## MEMORANDUM

**SUBJECT:** **On-Call Contract #17-067H-1; PO # 8115428**  
**Traffic Impact Study Reviews**  
**Task Order #11: Sterling Ranch East – Phase I Preliminary Plan TIS (SP224)**  
**First Review**

This memorandum provides a list of comments on the November 2022 Sterling Ranch East – Phase I Preliminary Plan Traffic Impact Study (TIS) prepared by LSC Transportation Consultants, Inc. for Classic SRJ. It should be noted that this TIS was uploaded to EDARP under the Sterling Ranch East Map Amendment (P2212), but it describes the traffic analyses for the Sterling Ranch East – Phase I Preliminary Plan (SP224). Our comments are based on requirements provided in the County’s Engineering Criteria Manual (ECM), Appendix B.

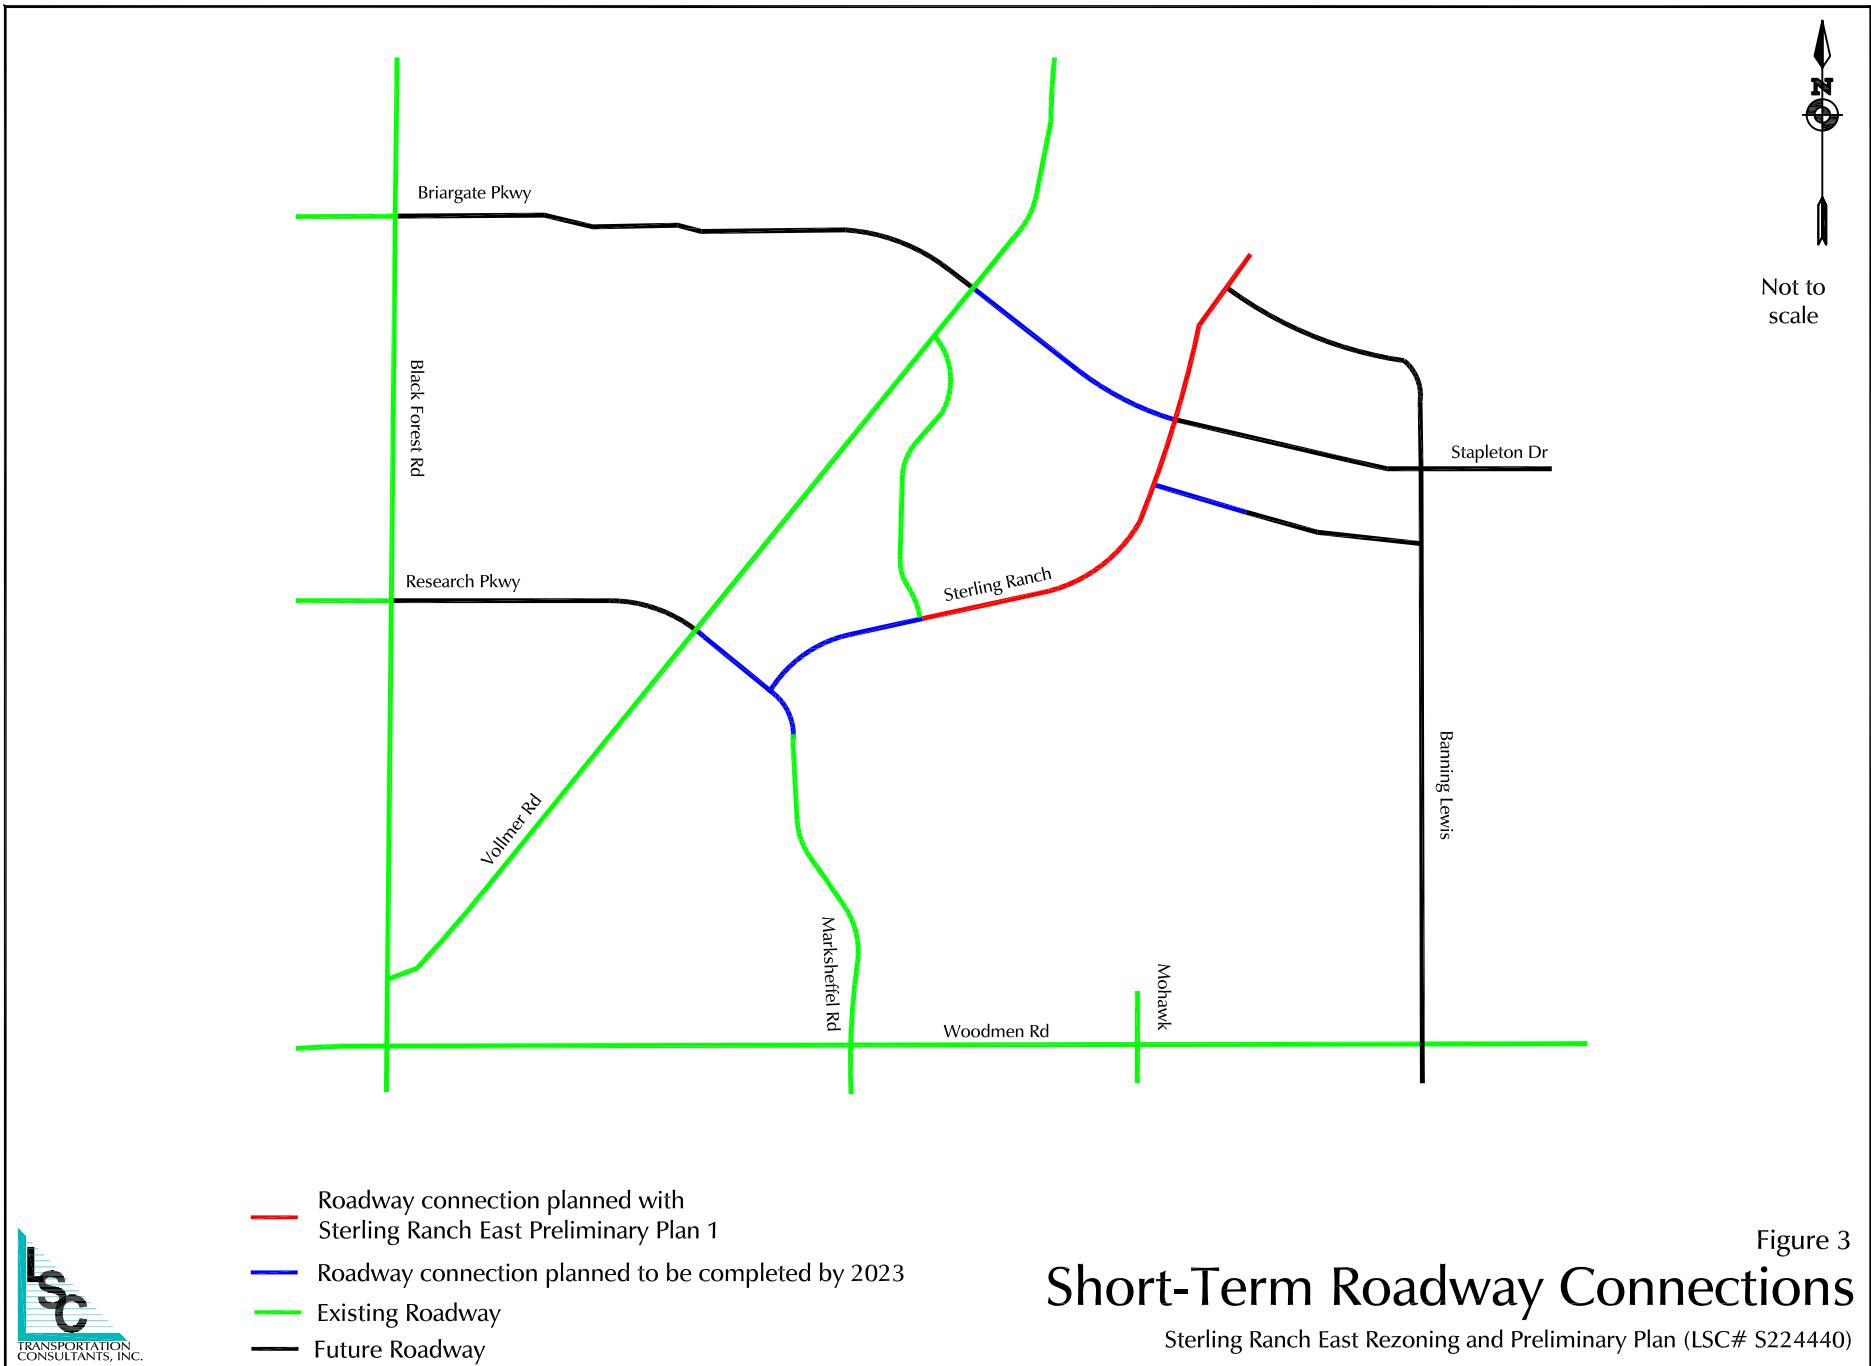
3. The following additional shortcomings have been identified in the Sterling Ranch East – Phase I Preliminary Plan (TIS):
  - a. The TIS commits to providing trail / sidewalk connections between the study area and the future Sand Creek Regional Trail (page 2). However, the connections are not shown on Figure 2 or described in the TIS. <sup>6</sup>

LSC Response: As requested, the trail connection has been added to Figure 2 and described in the TIS narrative.

Figure 4b

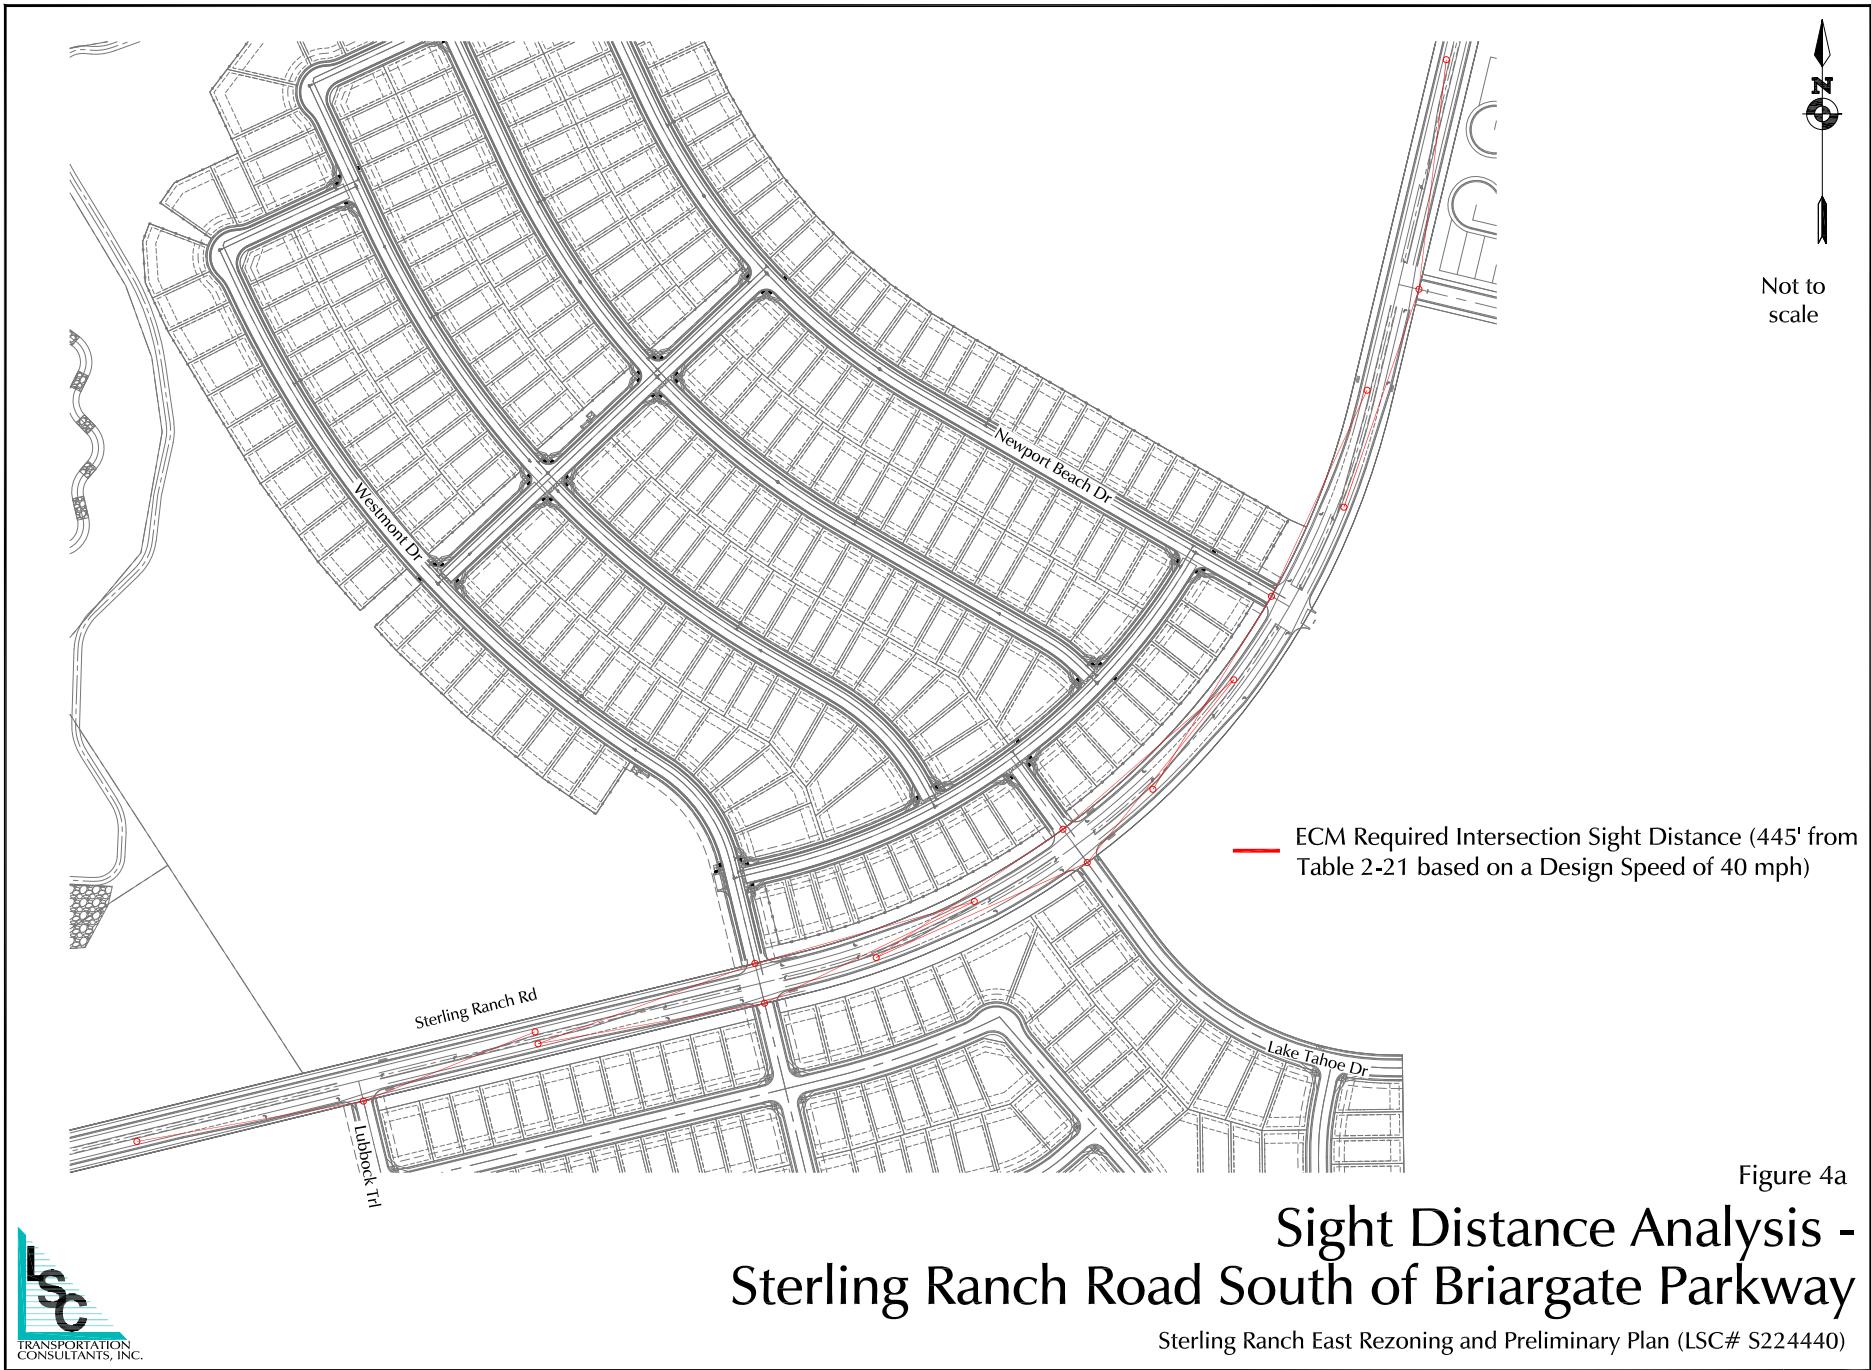
- b. The operational analysis (page 1) describes an exit-only access for Tract M along Sterling Ranch Road at Oak Park Place (#8). This access is not described elsewhere in the TIS, including the access text on page 3, the roadway connections on Figure 3, or the sight distance analysis on Figure 4a. The entry-only access to Tract M along Sterling Ranch Road

(#307) is also not described in the TIS, including the access text on page 3, the Sterling Ranch Road site access points on page 12, the roadway connections on Figure 3, or the sight distance analysis on Figure 4a. Both accesses are within 1,250 feet of the Briargate Parkway / Sterling Ranch Road signal and may conflict with turn lanes or queues approaching the signal. The Tract M access along Briargate Parkway was also noted as a concern in our Master TIS review.
